ICAG Inc. response to Volume 1 and 2

Karuah South Quarry SSD 17_8795

Karuah South Quarry SSD 17_8795

Figure 4.2 Wind Direction and Surrounding Residences

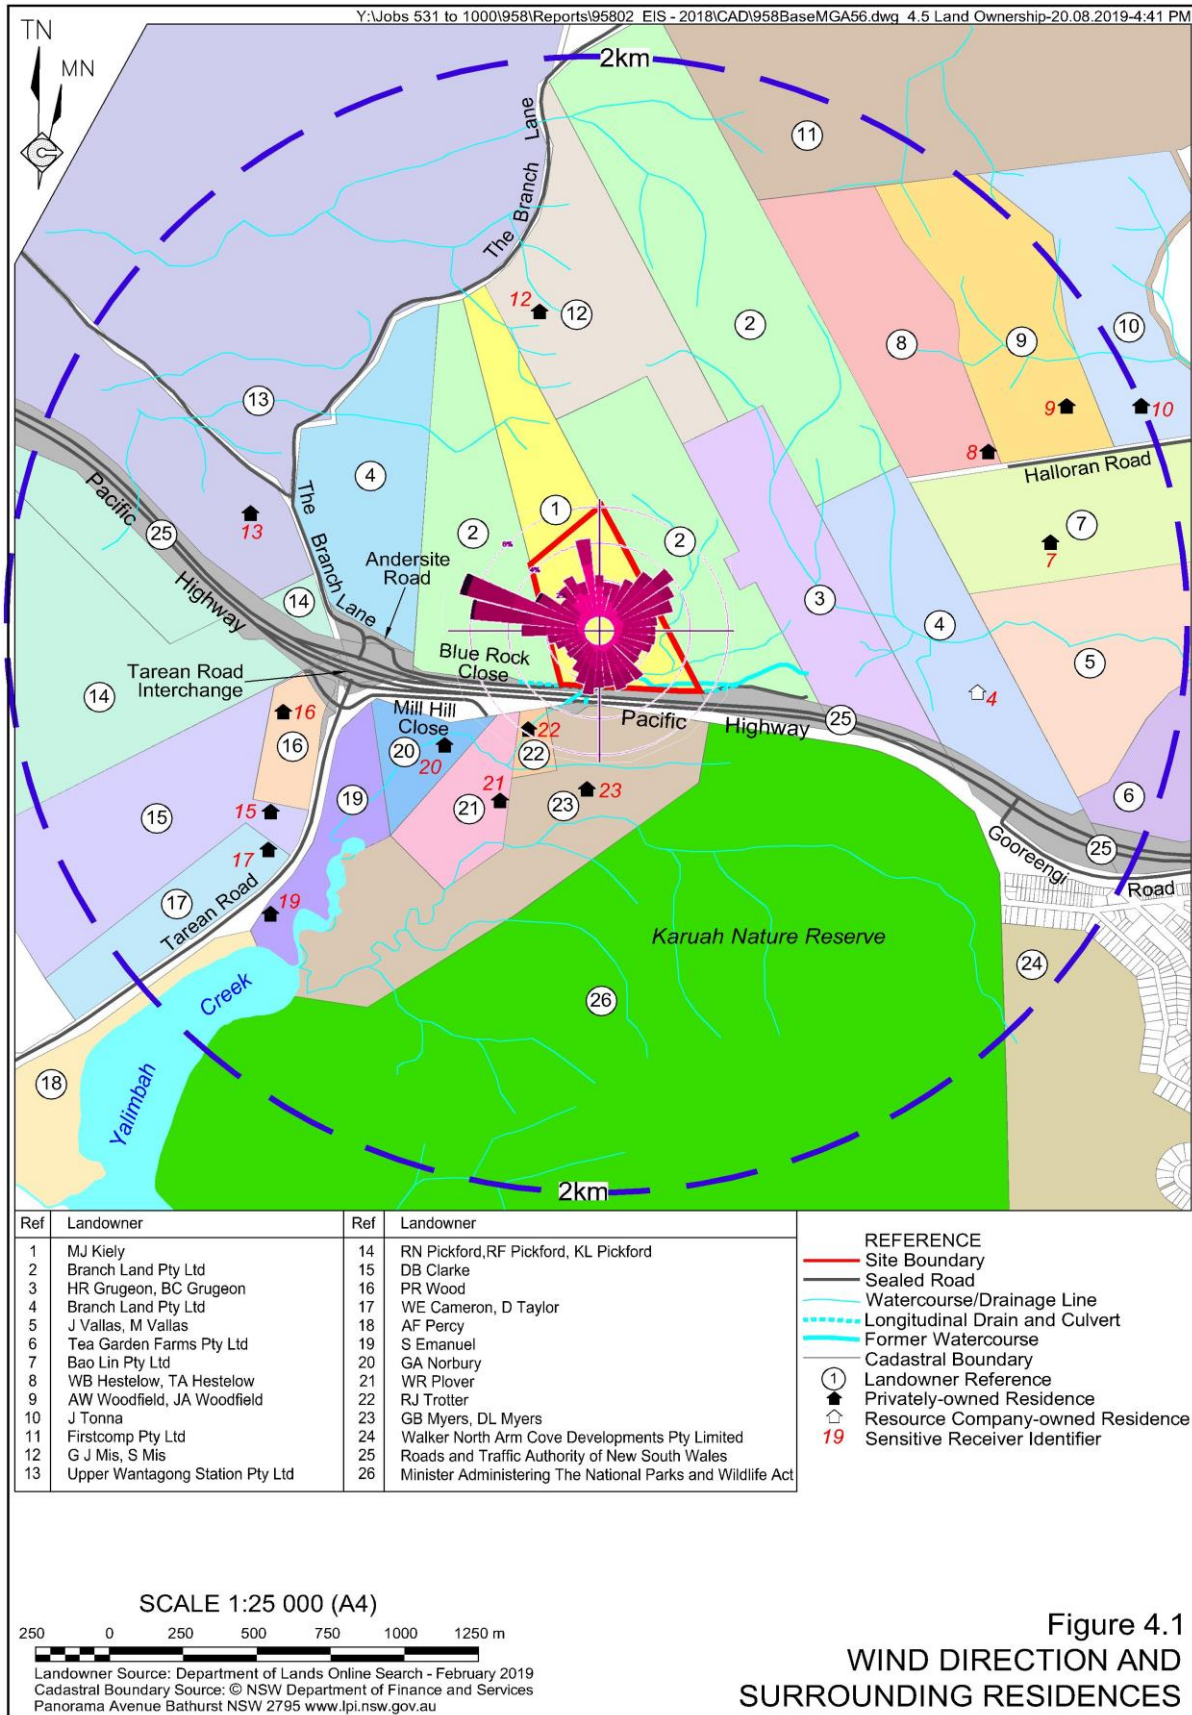
Wind direction map 1-42 we don't believe is accurate as wind would blow in all directions not just west as their diagramme is showing falsely we believe. Which means it would carry noise and dust to other areas outside of their map system graph. ICAG Inc. believes their mapping and diagrammes have been done to misrepresent the truth of noise and dust impacts. If this quarry is approved more of what Hunter Quarries does will continue by two companies.

Figure 4.3
PM₁₀ Frequency Distribution - Wallsend, Beresfield, Singleton and Singleton NW

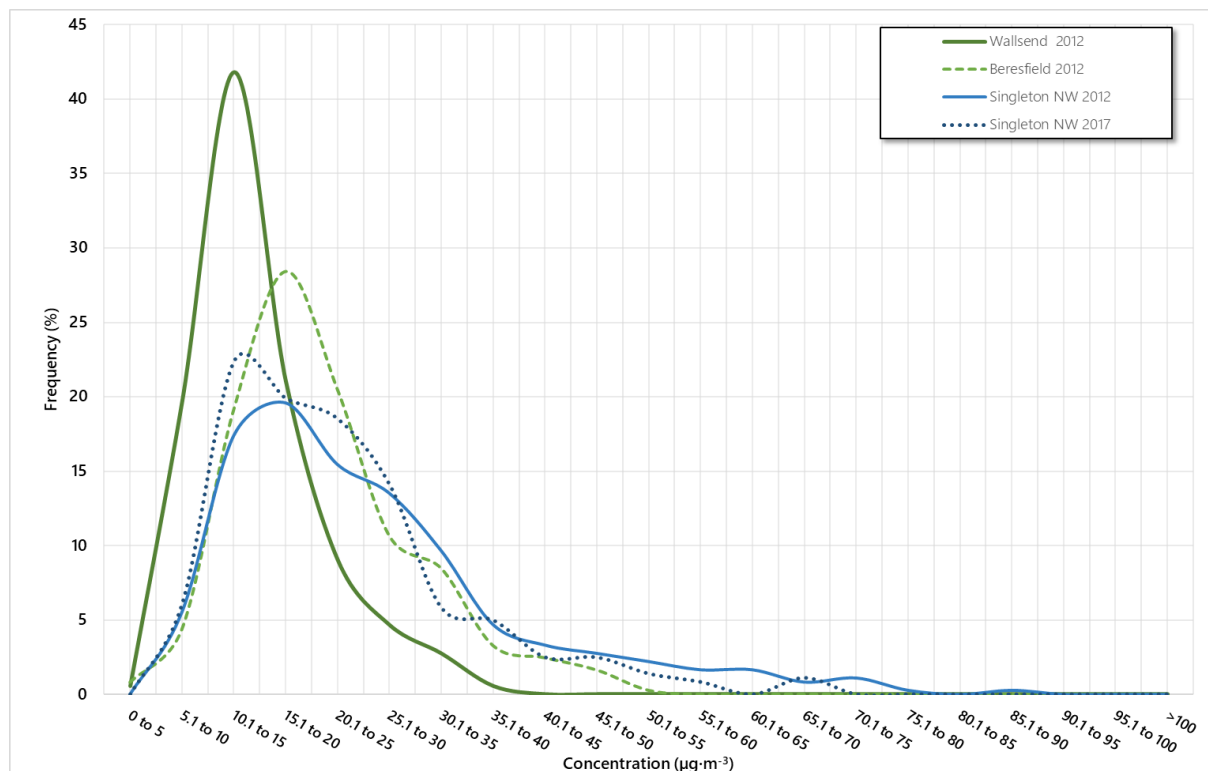
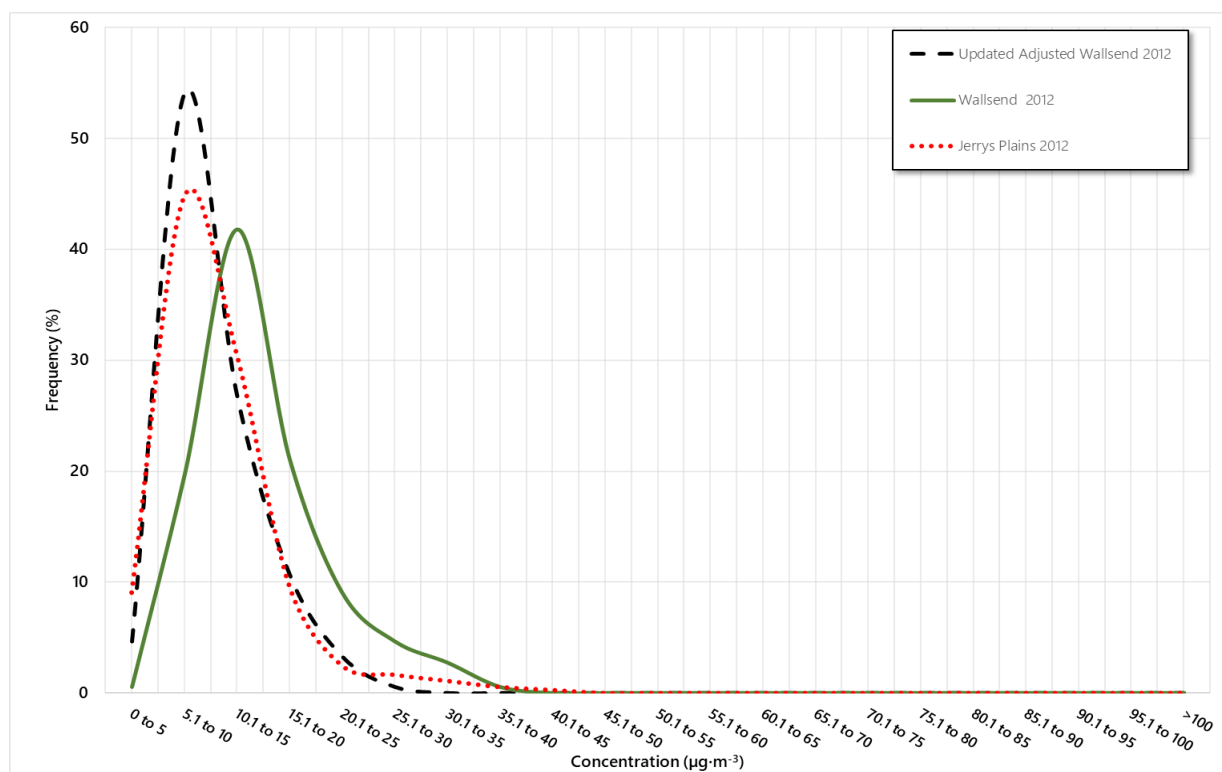
Air quality done at Wallsend is a bit too far away don't you think for a comparison? Need further explanation for this one.
